Re: Proposed Glass Beneficiation Plant (SSD 5267)

Property: No. 126 Andrews Road, Penrith

I refer to the notice of proposed development dated 5 June 2013 seeking Council comment on the proposed Development Application for the construction and operation of a Glass Beneficiation Plant at the above address.

LONGITUDINAL SECTION CENTRELINE - SWALE No.1

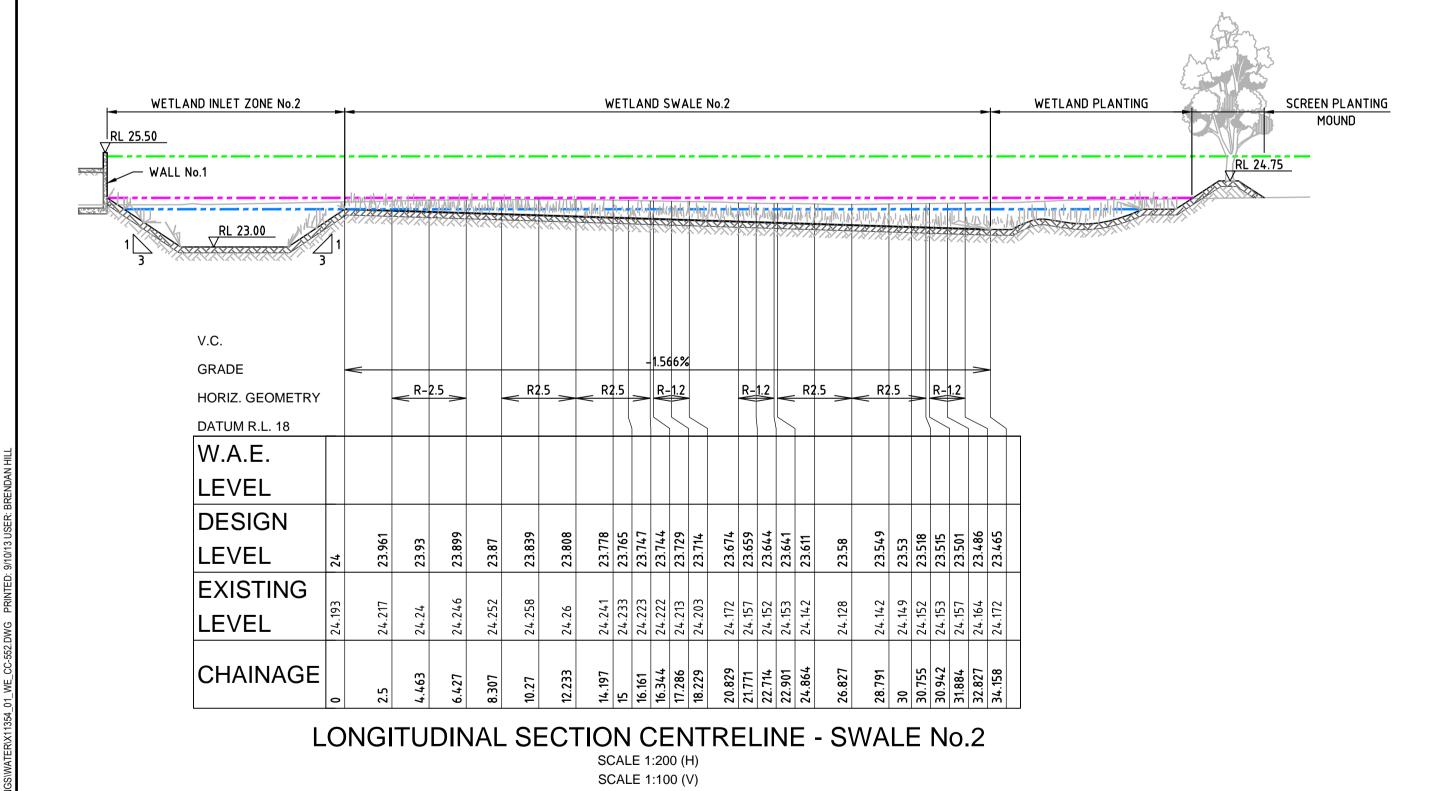
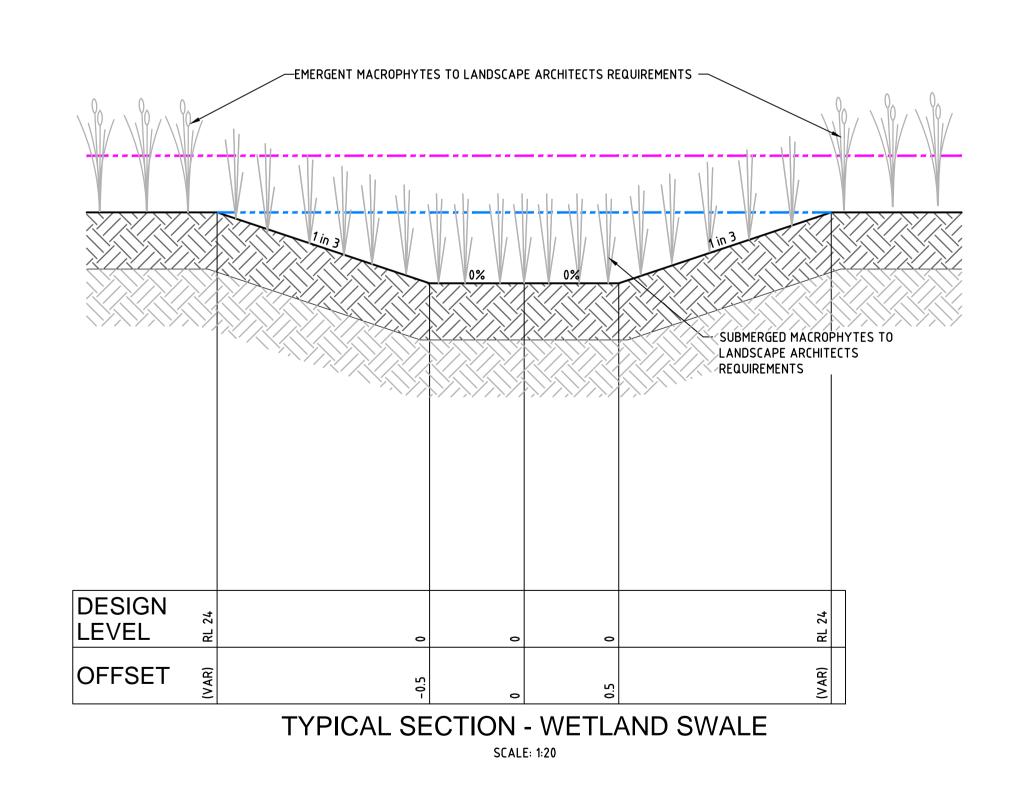
- Further details on the swales must be provided with regards to their design parameters. The design parameters should be based on the numeric modelling to demonstrate water quality treatment functionality. The swales should incorporate filter media that meets the current specifications of the Bioretention Filter Media Guidelines produced by the Facility for Advancing Water Filtration or demonstrated equivalent and verified by a soil laboratory registered by the National Association of Testing Authorities. The swale design must also consider access for cleaning and maintenance. Access requirements should include hard access to base; ease of access to inlet area and adequate access to reach flush points.

_	Drawing Title:
	WETLAND SECTIONS

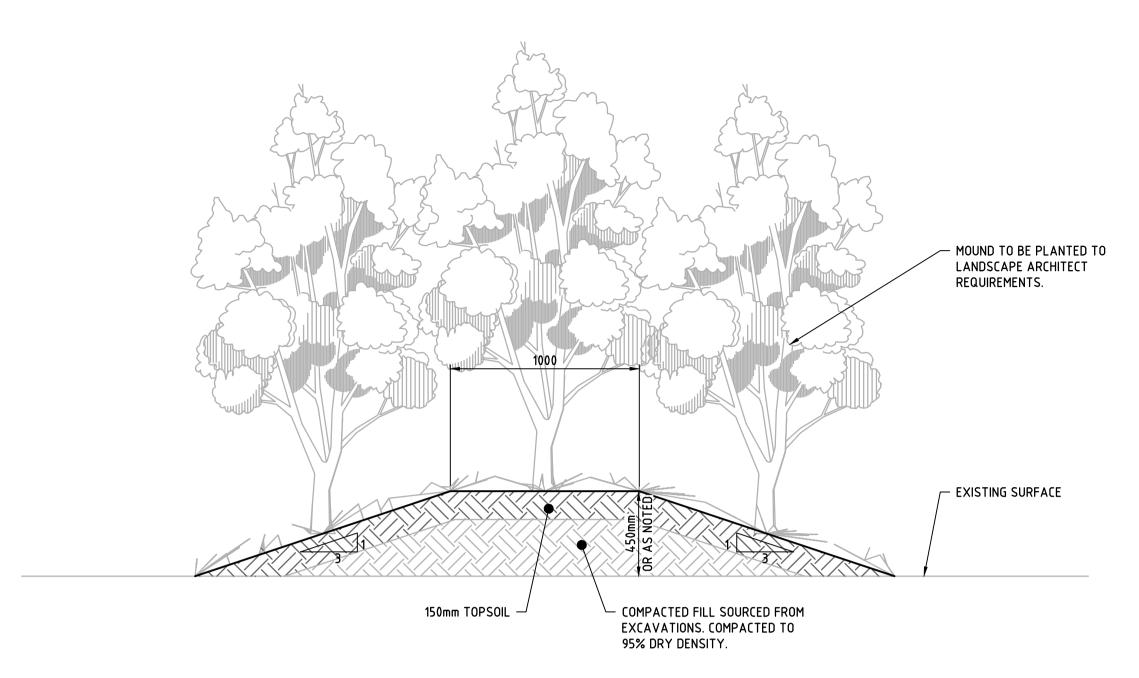
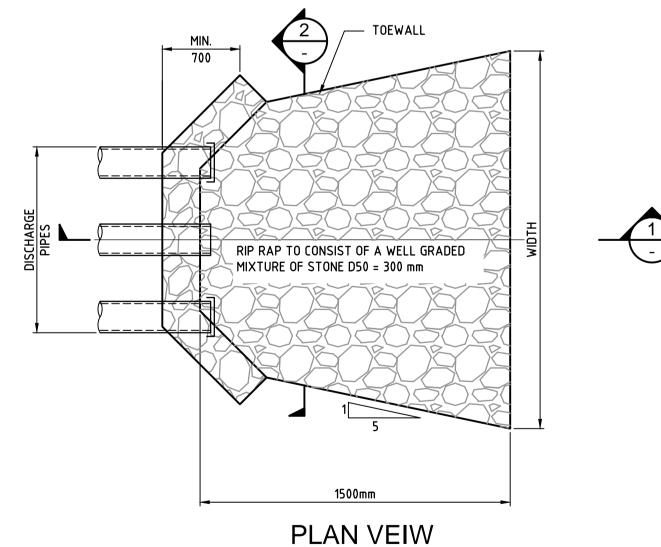
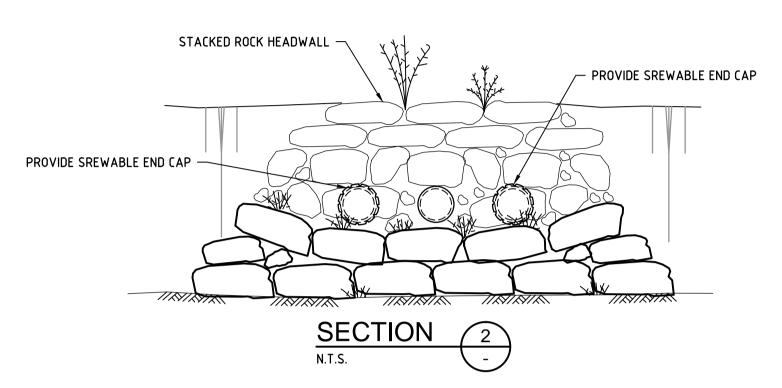
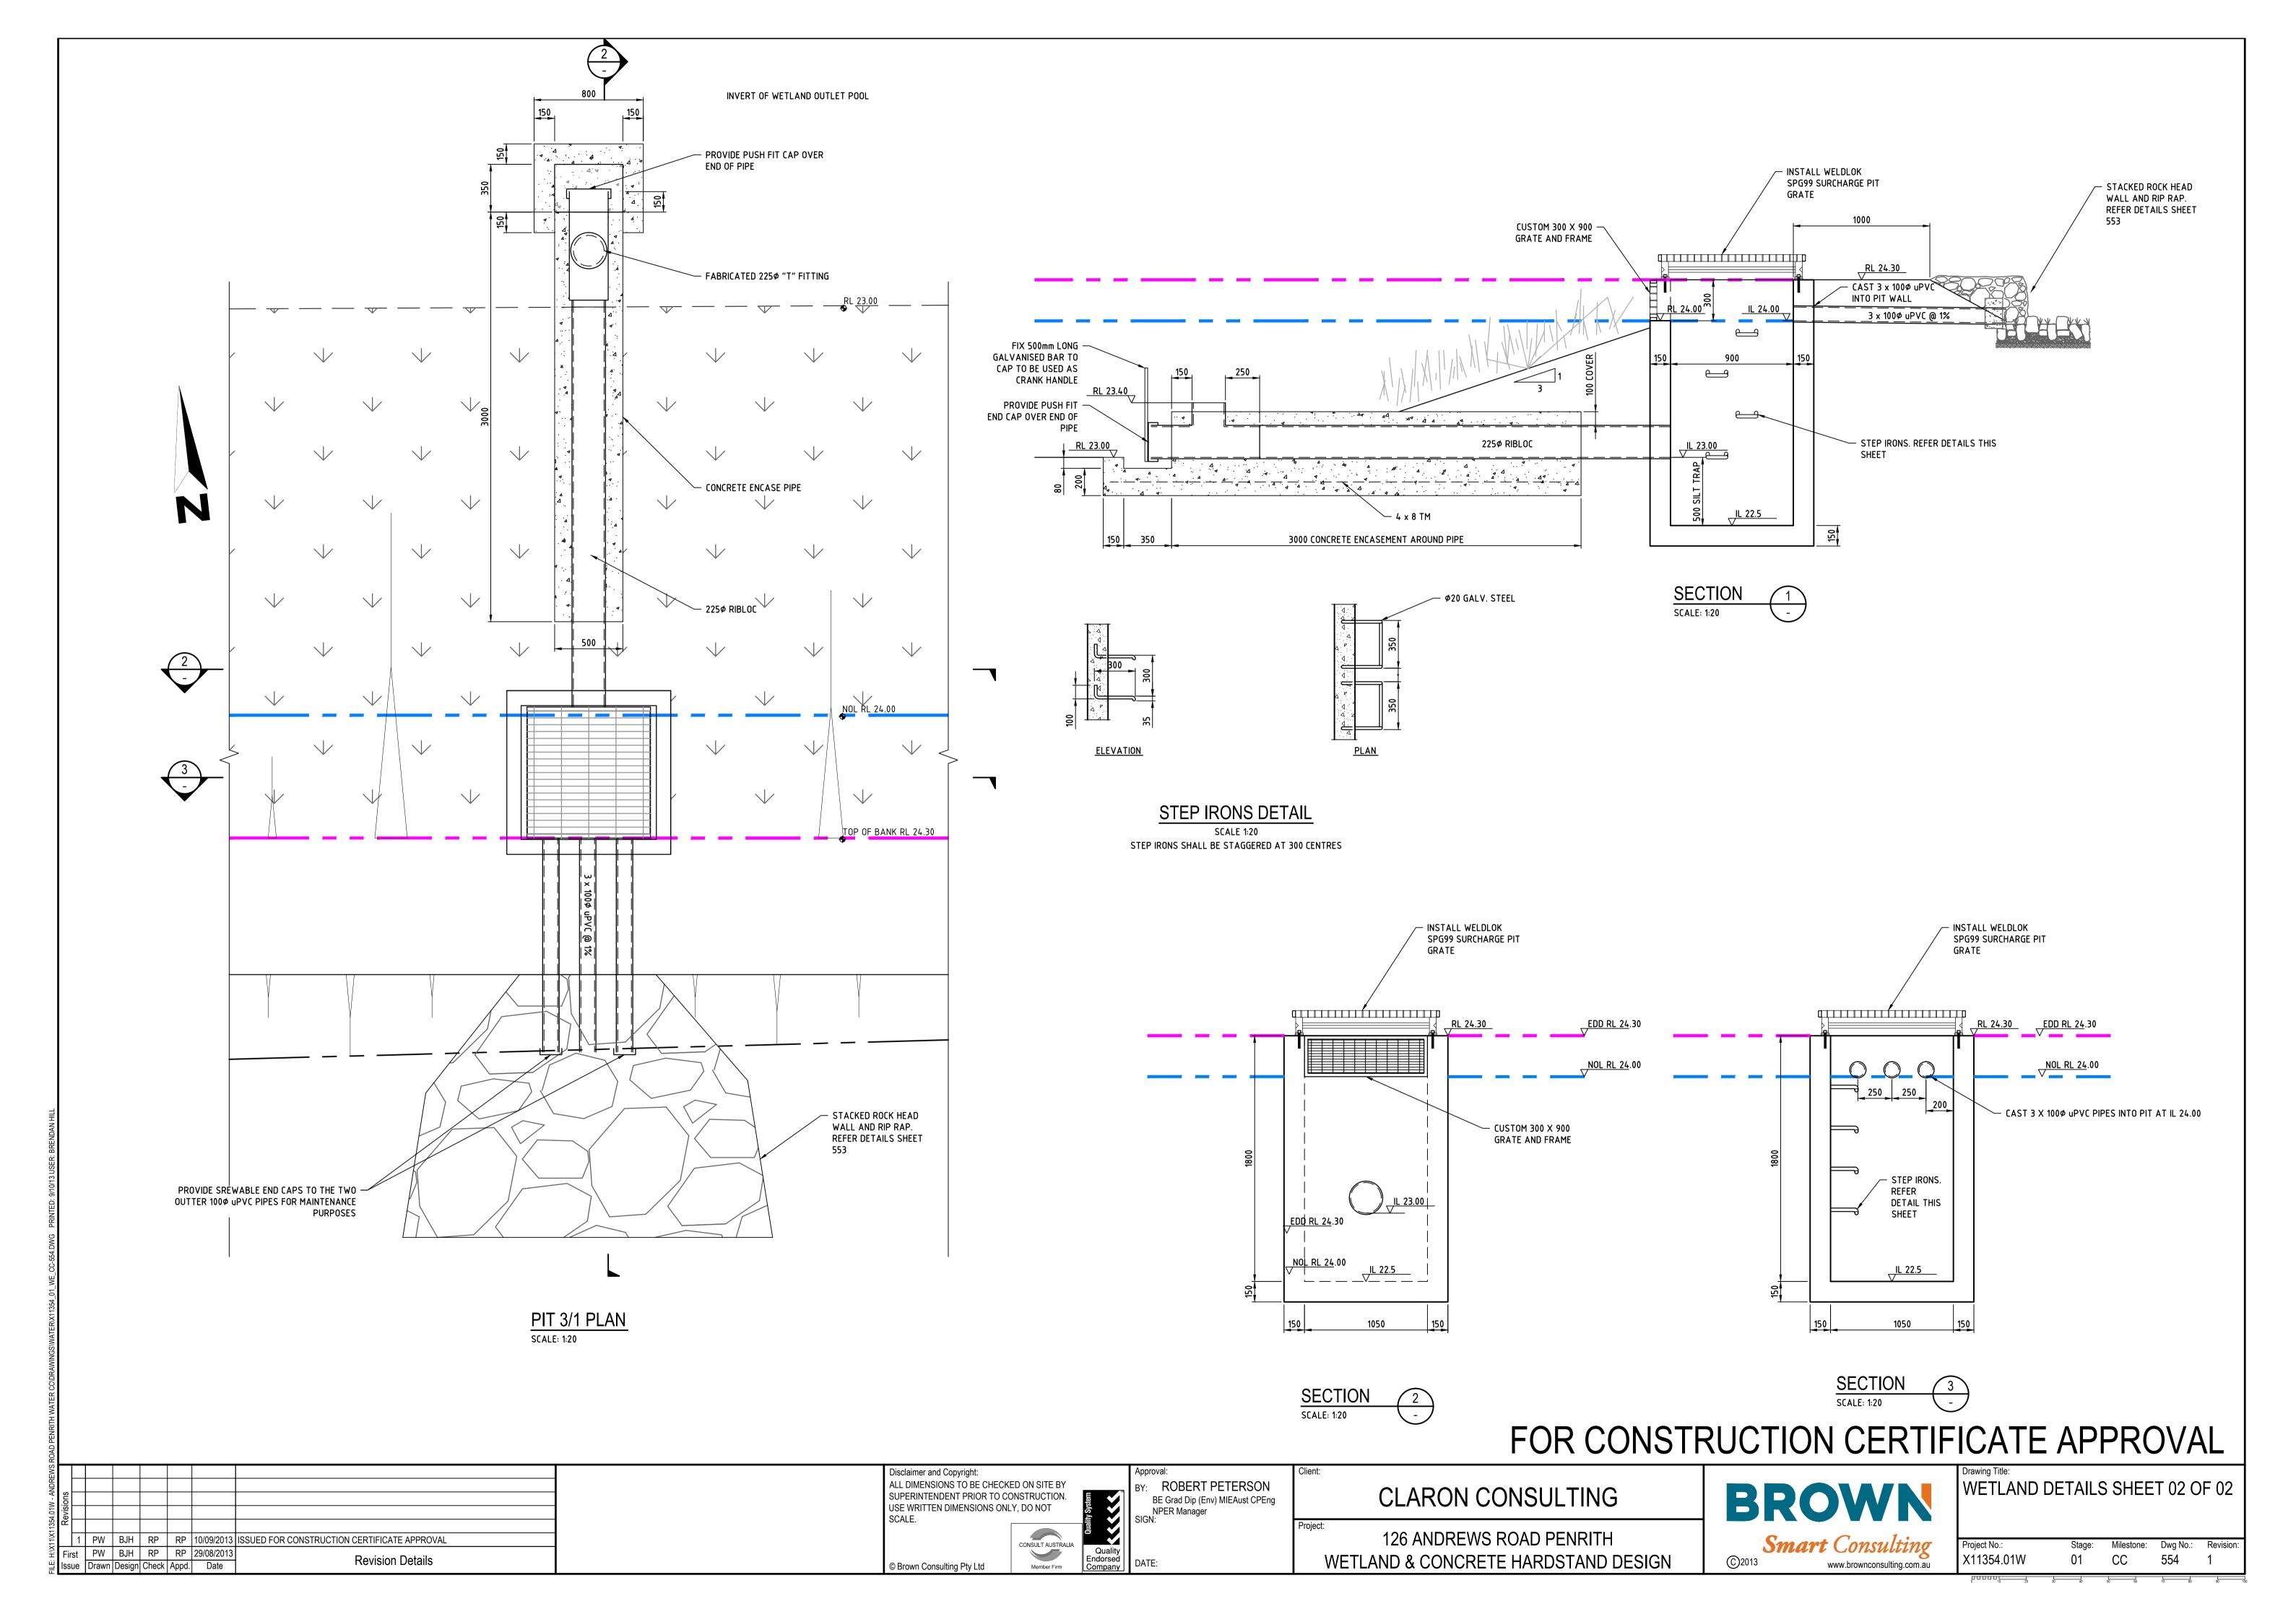
- No details have been provided on the design parameters of the constructed wetland, such as depth or where macrophyte zones are located. BioDesign's landscape planting plan shows generic detail only. Best practice wetland design incorporates benching or bands of shallow and deep water macrophytes perpendicular to the direction of flow to guarantee contact time with the vegetation. The wetland layout needs to demonstrate that it is fit for purpose and results in biological treatment as well as physical treatment. A comprehensive monitoring regime must also be developed and implemented for the commissioning and ongoing functioning of the wetland to ensure water quality objectives are achieved.
